## KITTITAS COUNTY COMMUNITY DEVELOPMENT SERVICES

**July 22<sup>nd</sup>, 2016**

**RE: McElliott Agricultural Short Plat (SP-16-00009)**

The Kittitas County Community Development Services Department has determined that the **McElliott Agricultural Short Plat (SP-15-00009)** is a complete application and hereby grants *conditional preliminary approval* subject to the following conditions:

# McELLIOTT AGRICULTURAL SHORT PLAT PART OF SECTION 20, T. 18 N., R. 19 E., W.M. KITITAS COUNTY, WASHINGTON

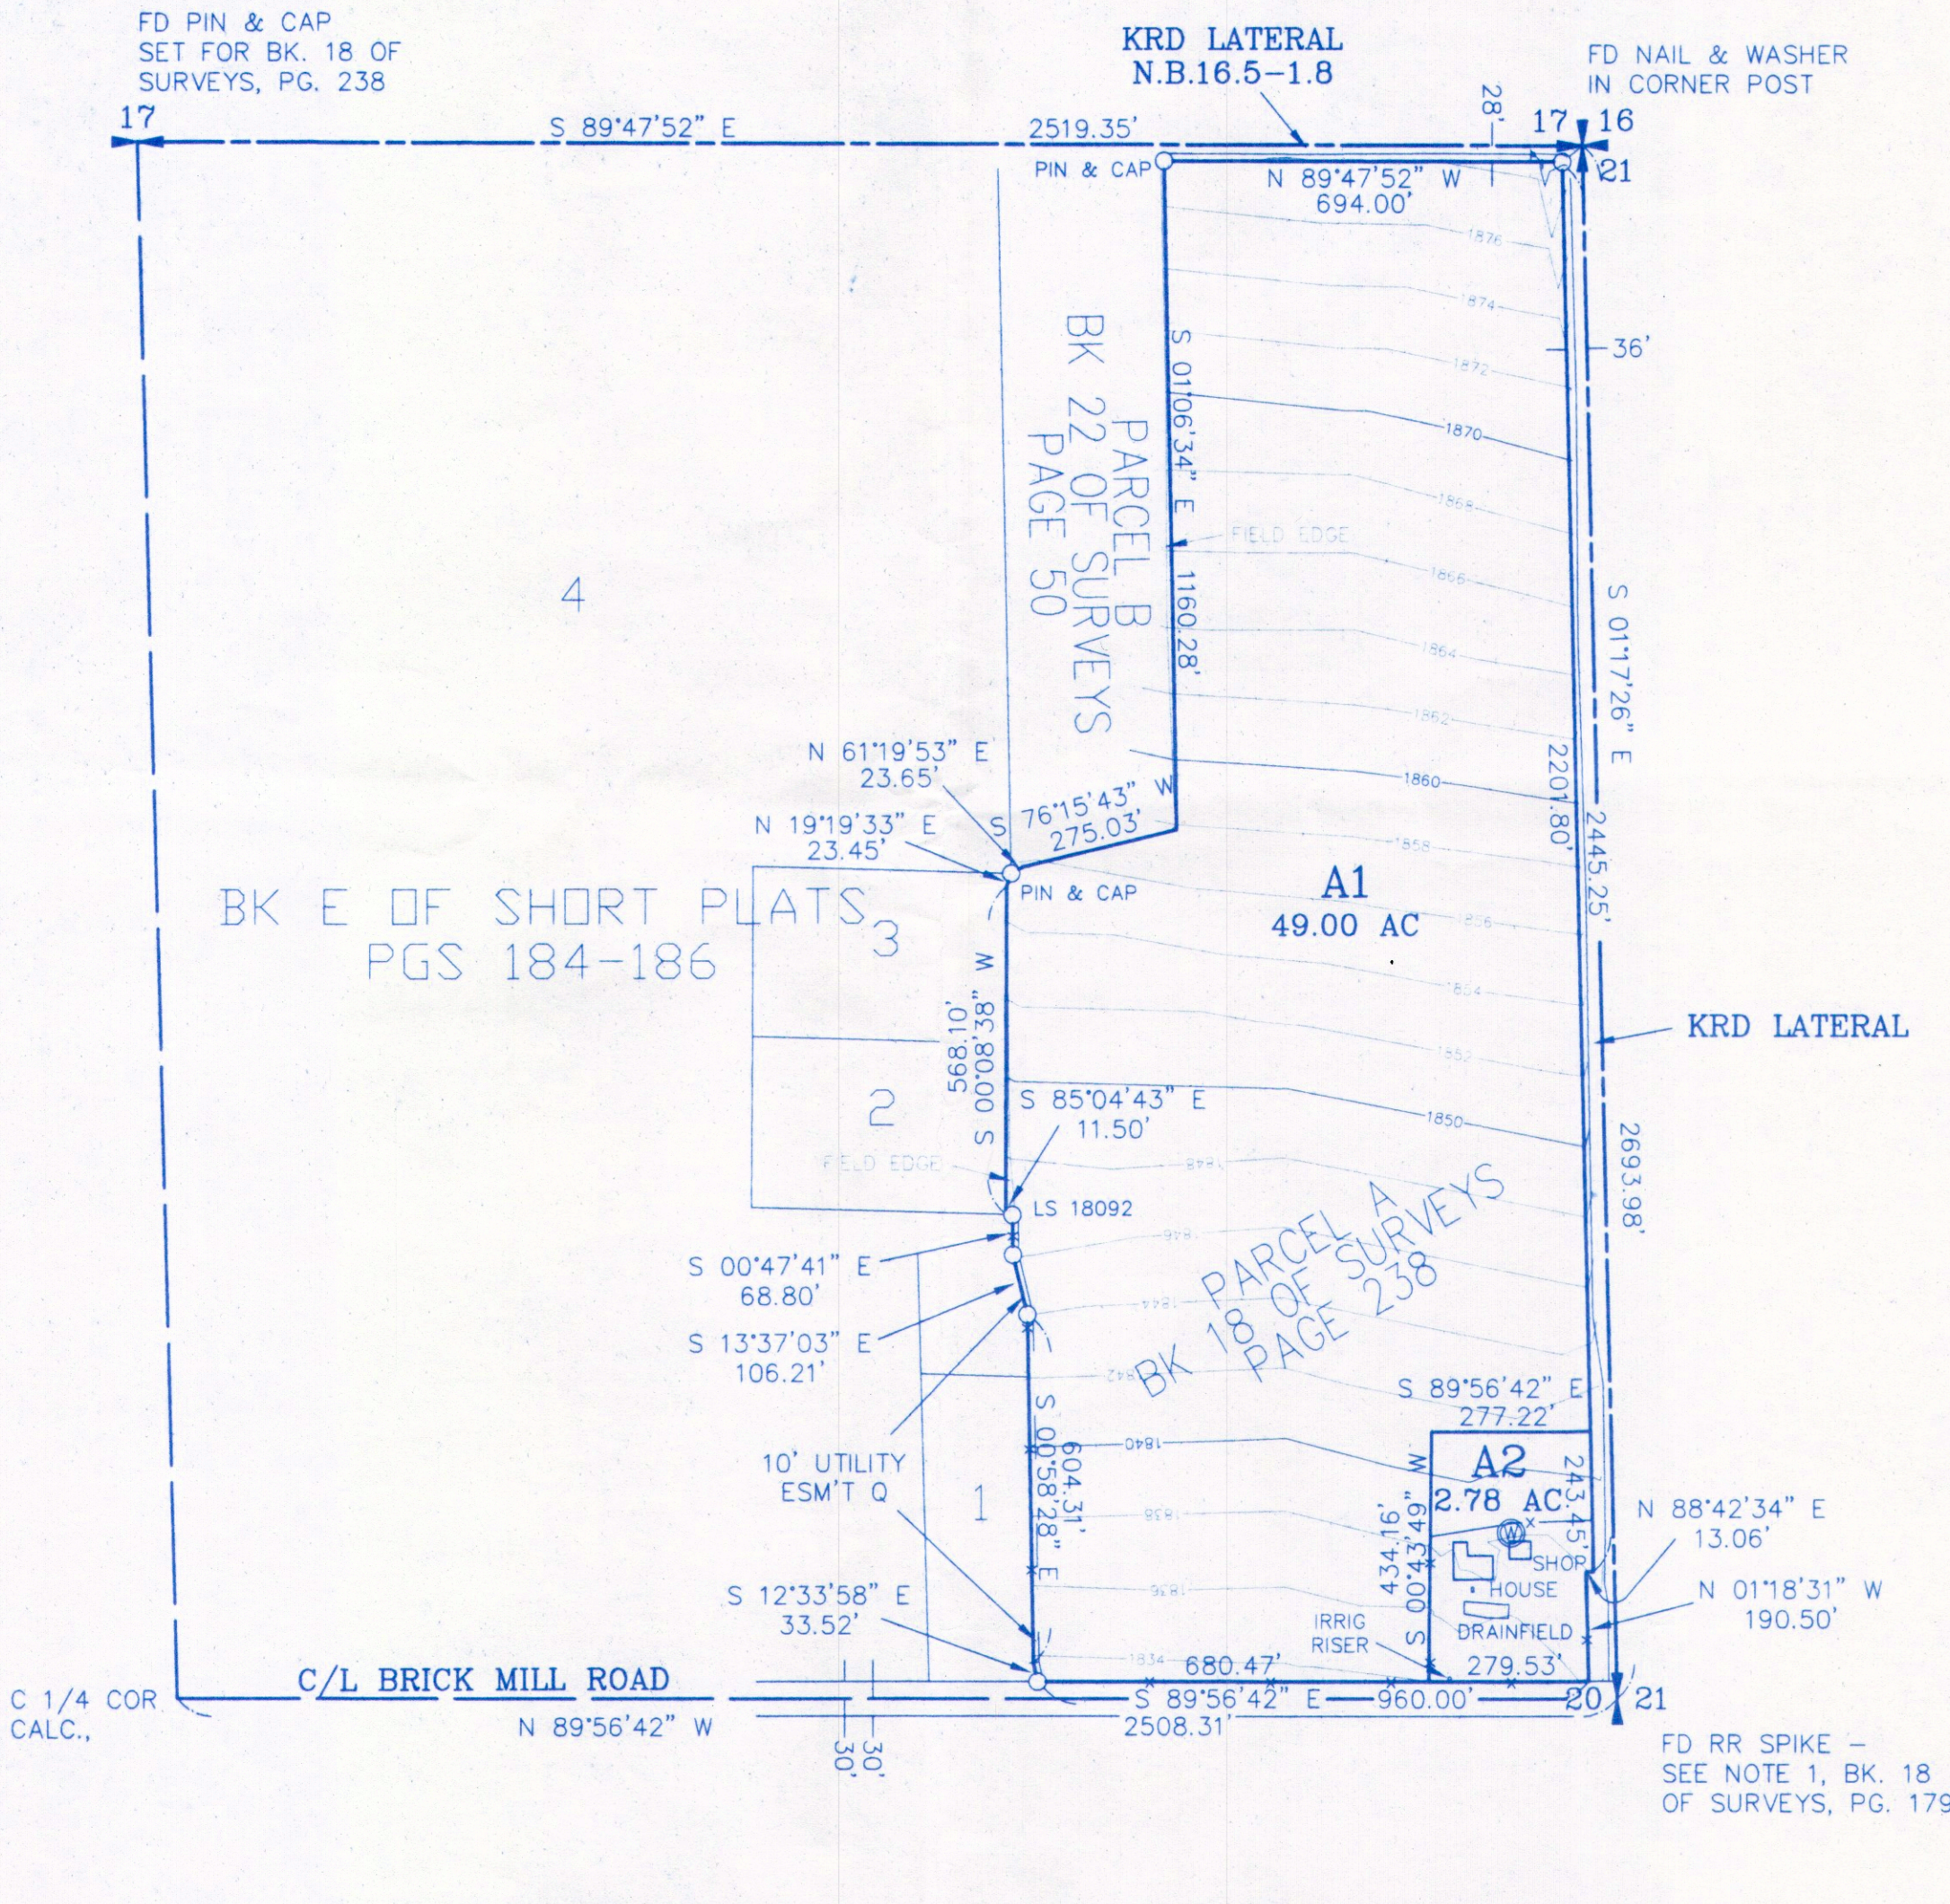
1. Both sheets of the final mylars shall reflect short plat number SP-16-00002 and an accurate legal description shall be shown on the face of the final plat. Engineers and Surveyors need to be cognizant of all of the requirements related to Final Plats (KCC 16.20) and Survey Data and Dedications (KCC 16.24). The final plat must be submitted in full conformance with these chapters of Kittitas County Code; **non-compliant mylars will be rejected and returned to the applicant.**

4. All Floodplain and wetlands shall be delineated on the face of the final mylar.
  5. Should ground disturbing or other activities related to the proposed short plat result in the inadvertent discovery of cultural or archaeological materials, work shall be stopped in the immediate area and contact be made with the Washington State DAHP. Work shall remain suspended until the find is assessed and appropriate consultation is conducted. Should human remains be inadvertently discovered, as dictated by Washington State RCW 27.44.055, work shall be immediately halted in the area and contact made with the coroner and local law enforcement in the most expeditious manner possible.
